CROWN STREET DEVELOPMENT APPLICATION
SUMMARY OF SUBMISSIONS

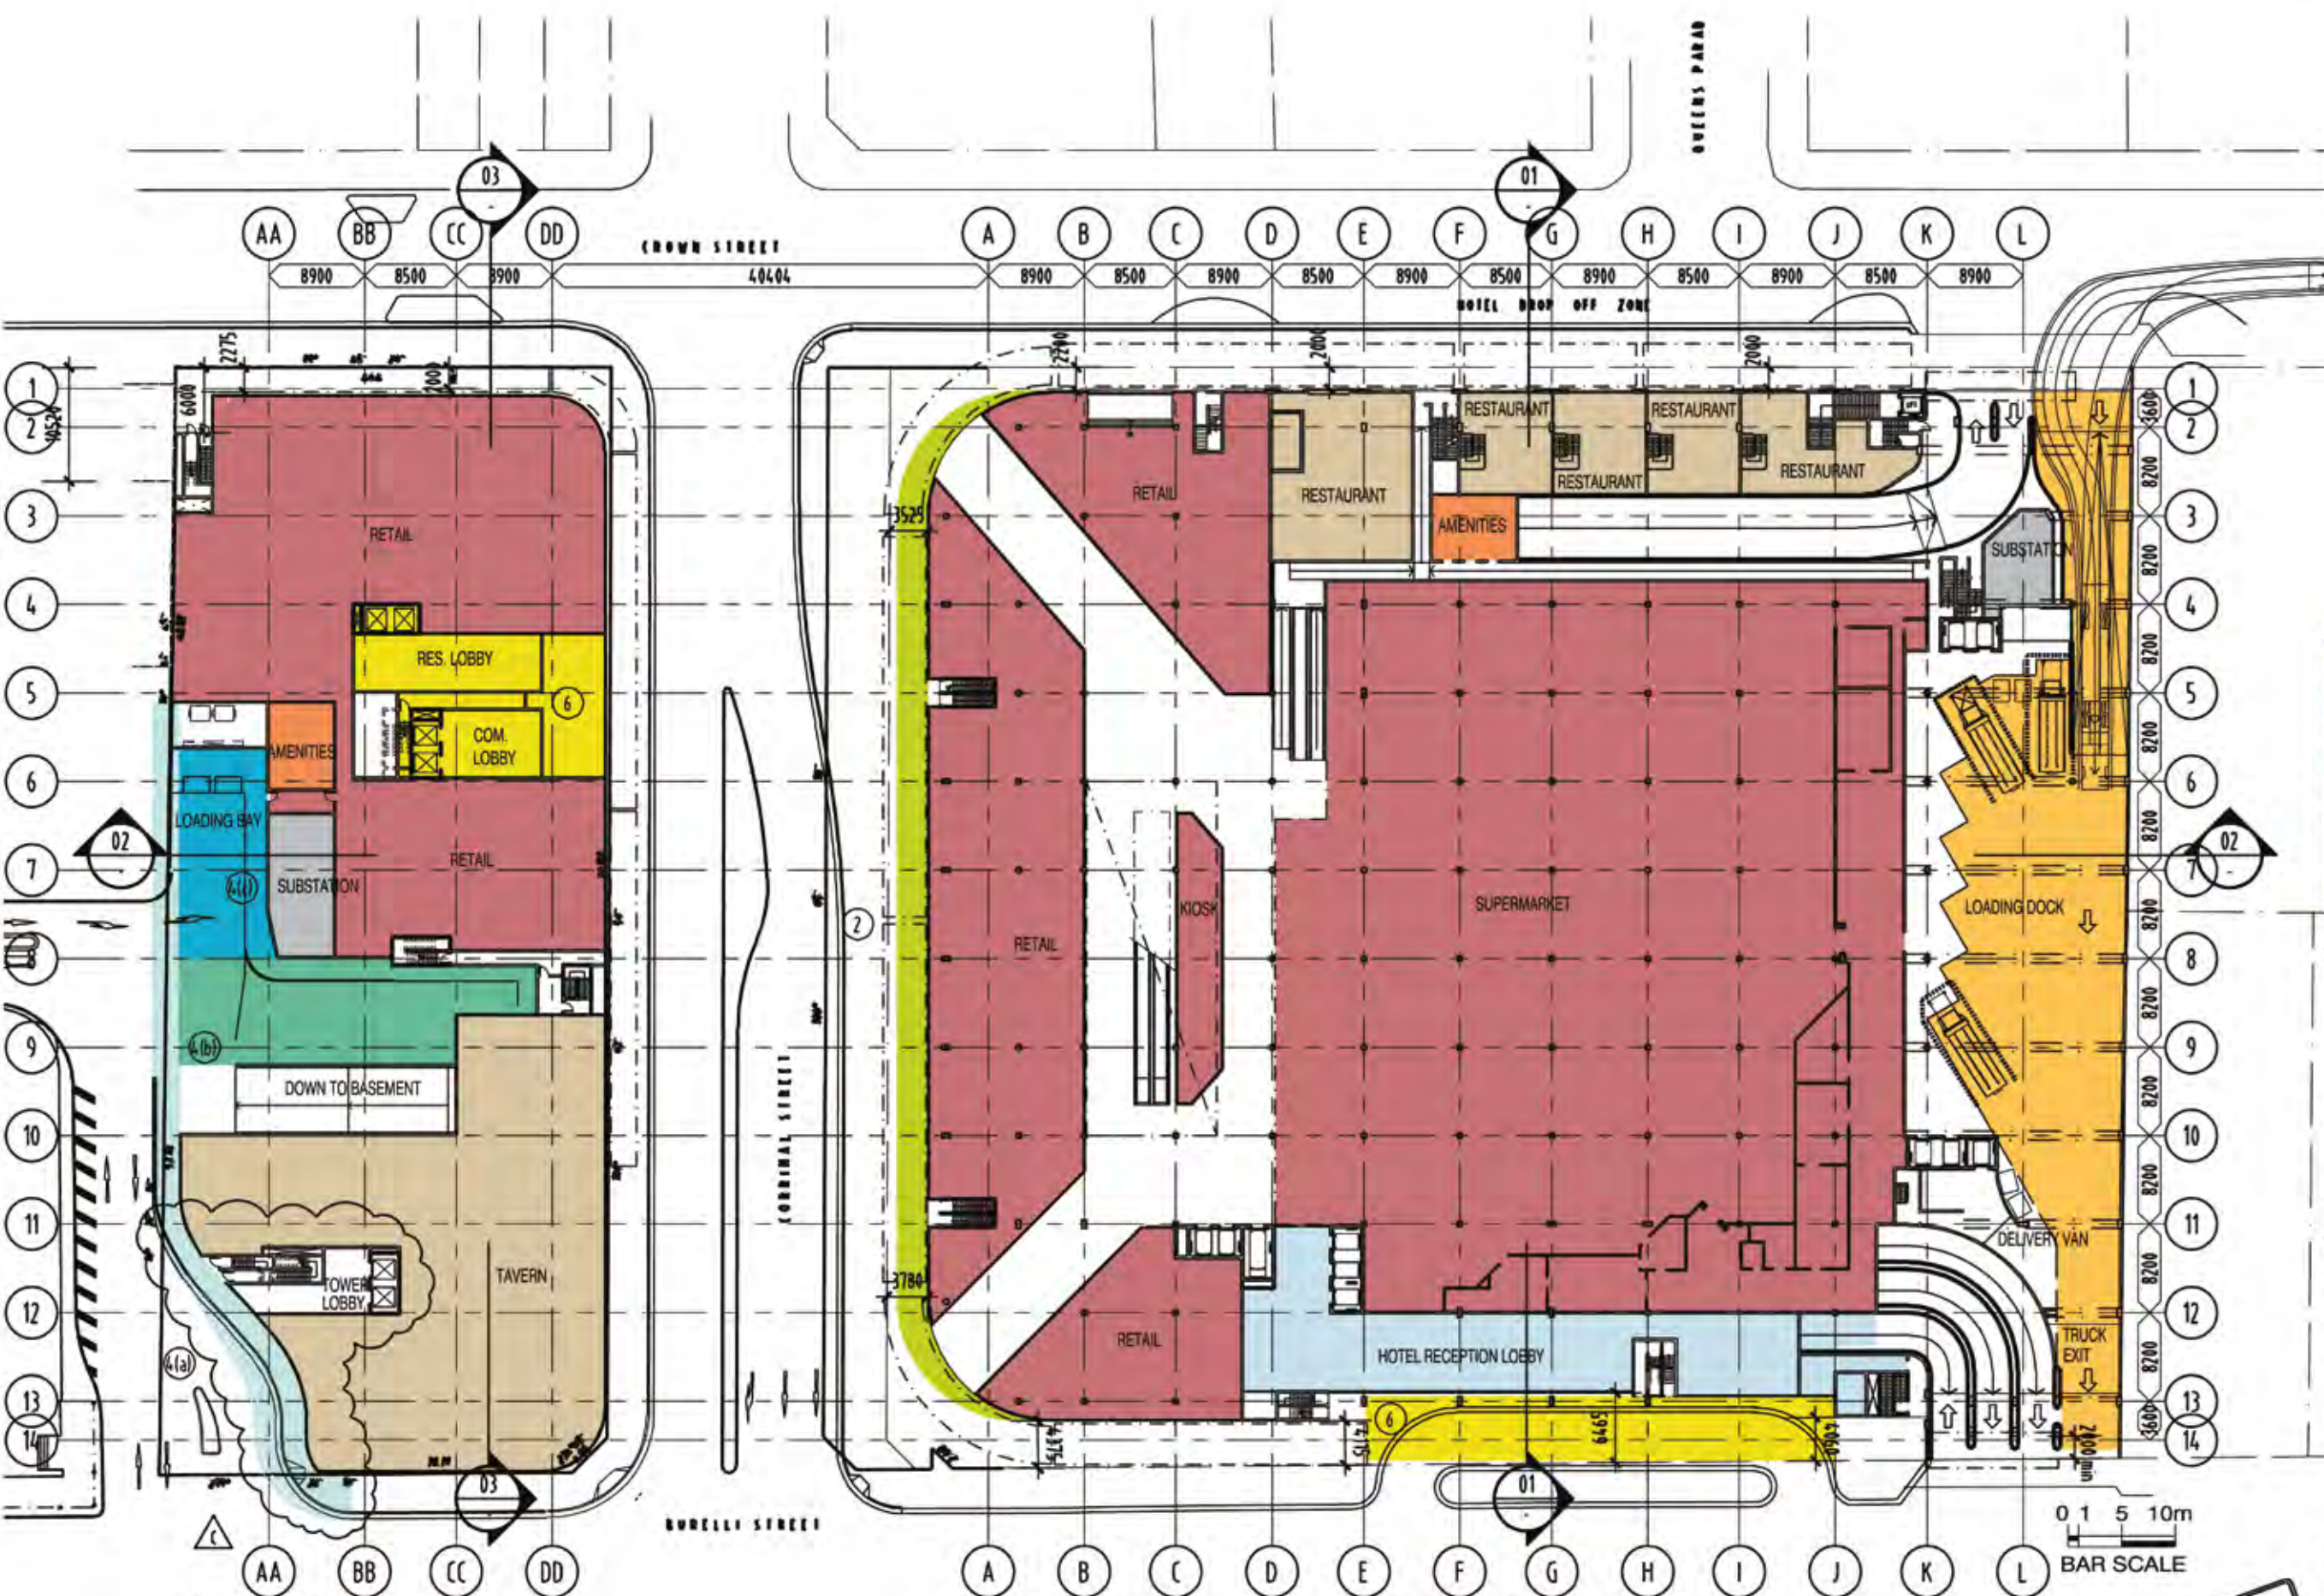
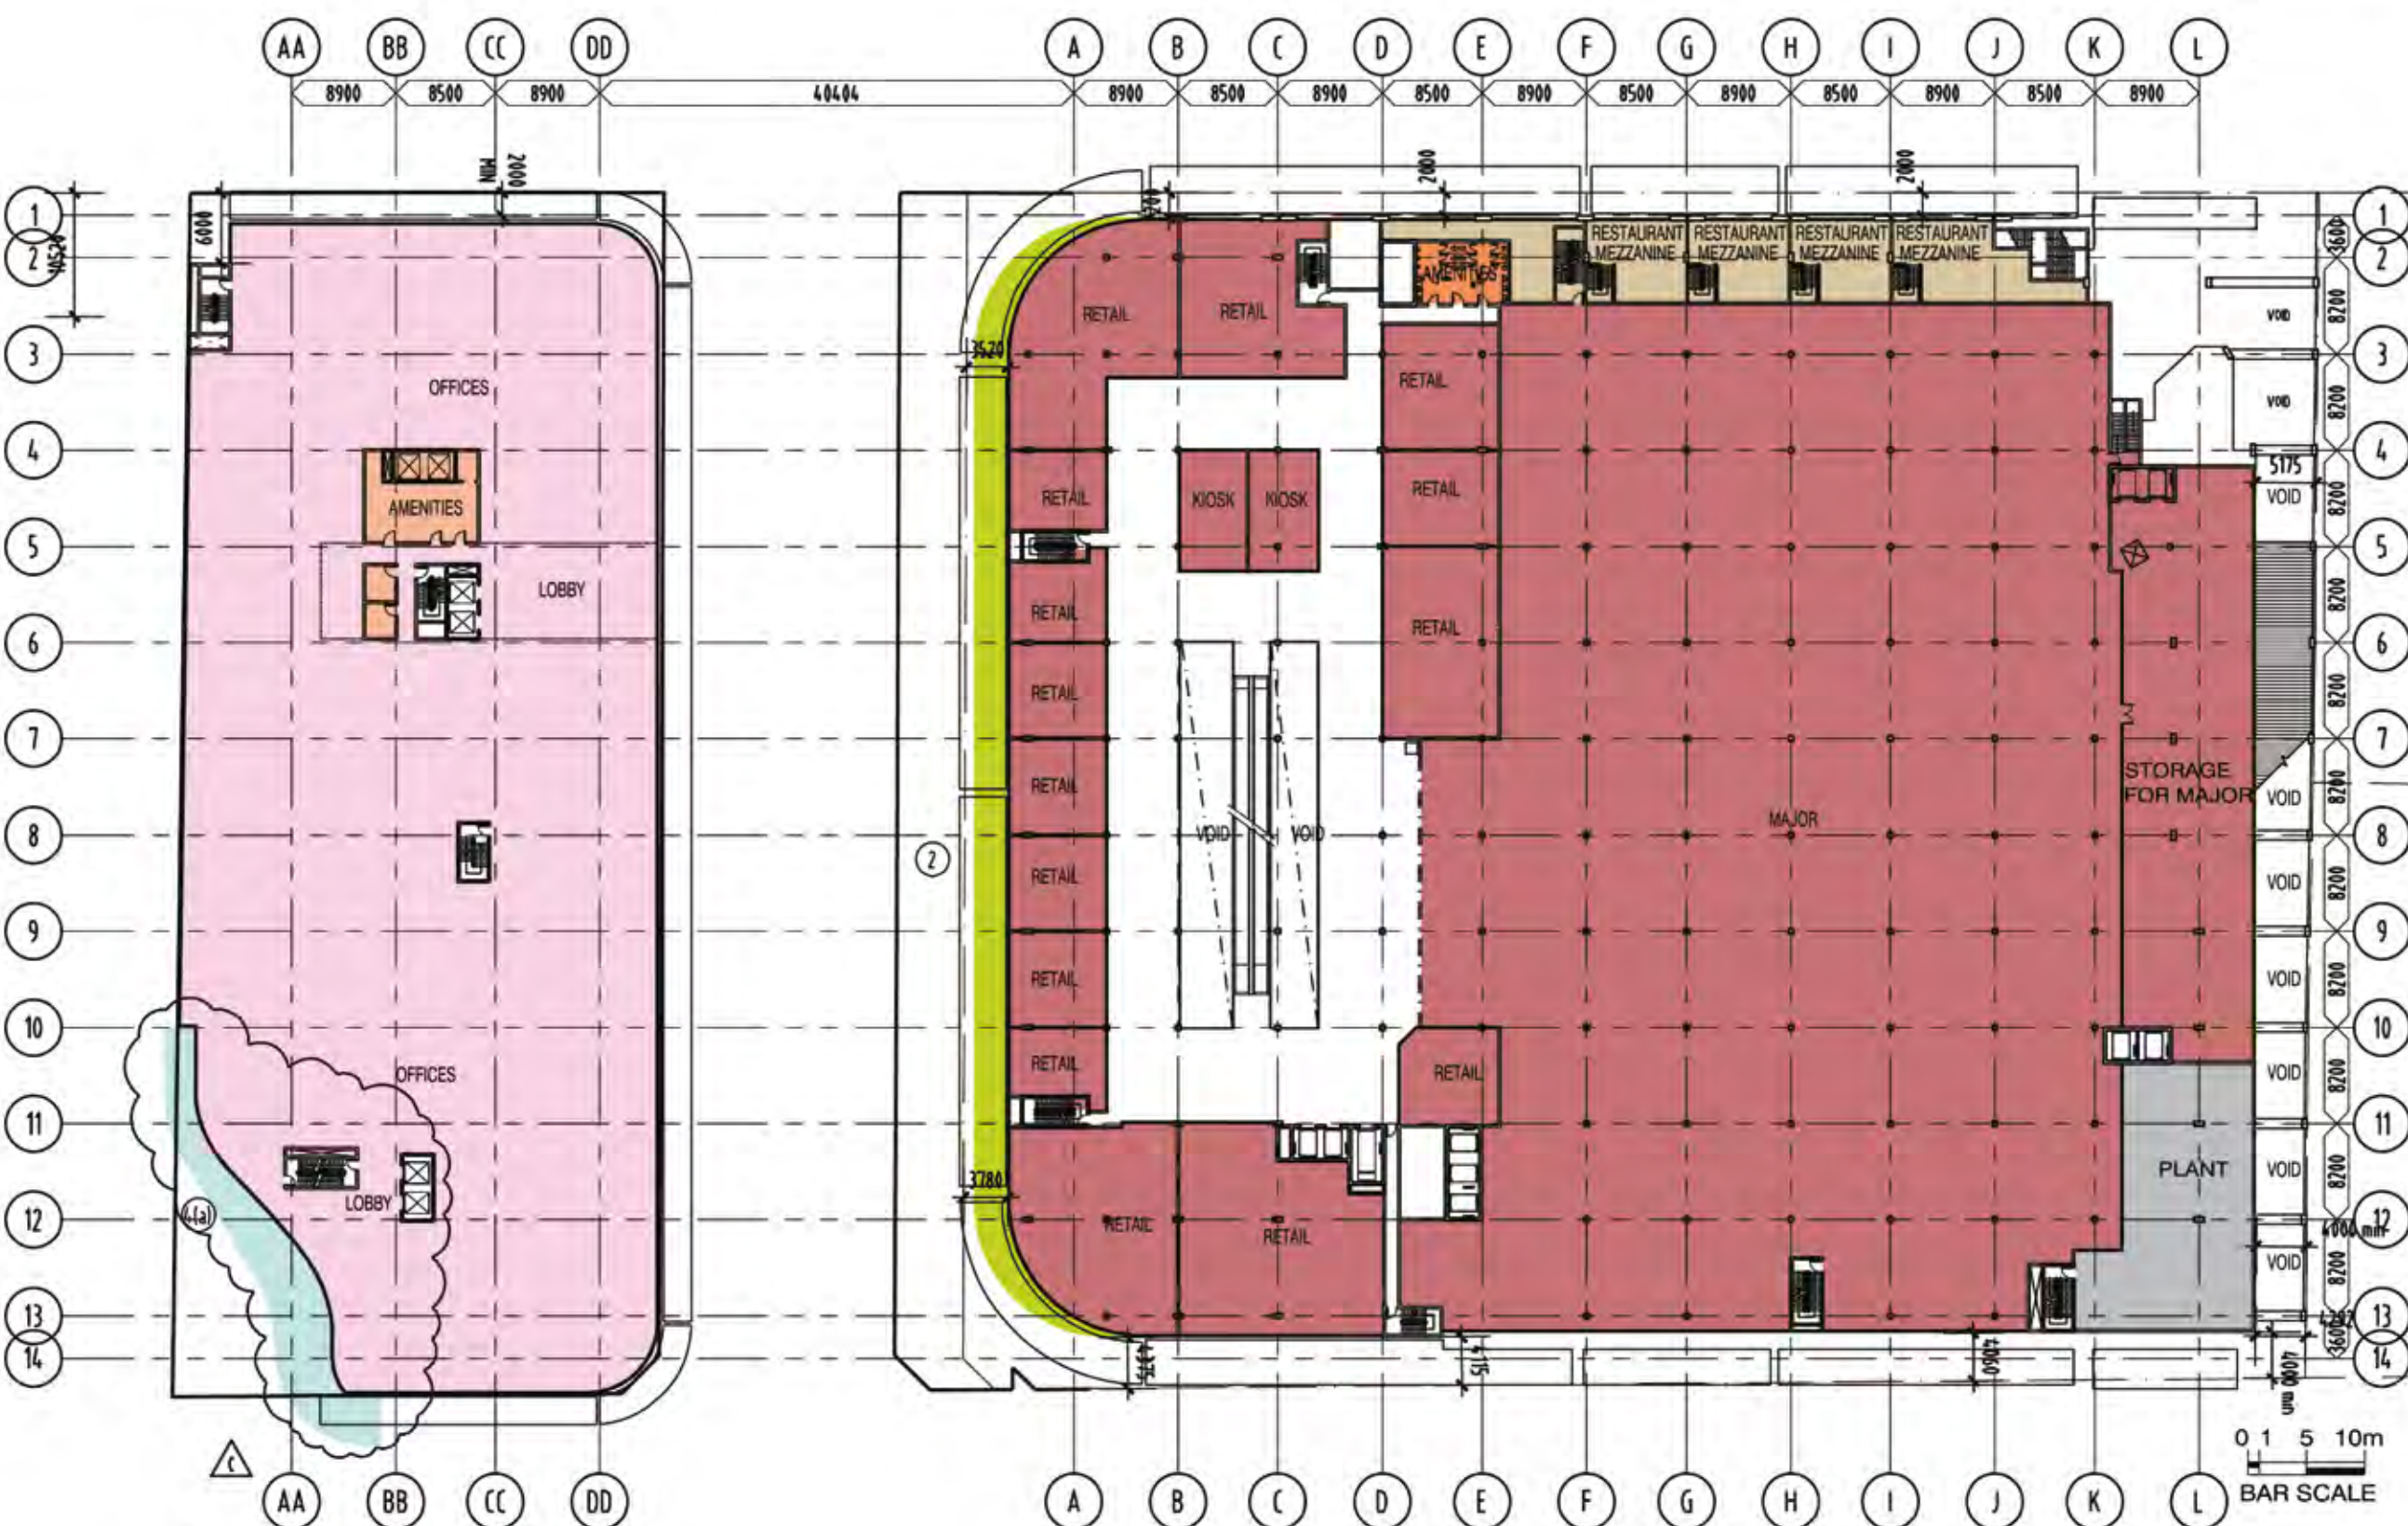
Ref No.	Submitter	Issue	Comment	Recommended Action
		6.2 Proposal is inconsistent with road widening reservations. • Proposal for Dwyer's site encroaches on road reserve along Corrimal Street – amended plans required to include setback. • Oxford site shall be redesigned to allow for road widening in accordance with WCC Infrastructure Division's Dwg No. 4268, 01/08.	Amendments have been made to address the proposed road widening of Corrimal Street. See also address in Urbis covering letter. As also addressed in the Urbis letter, it is considered onerous for Council to require further road widening of Town Hall Place.
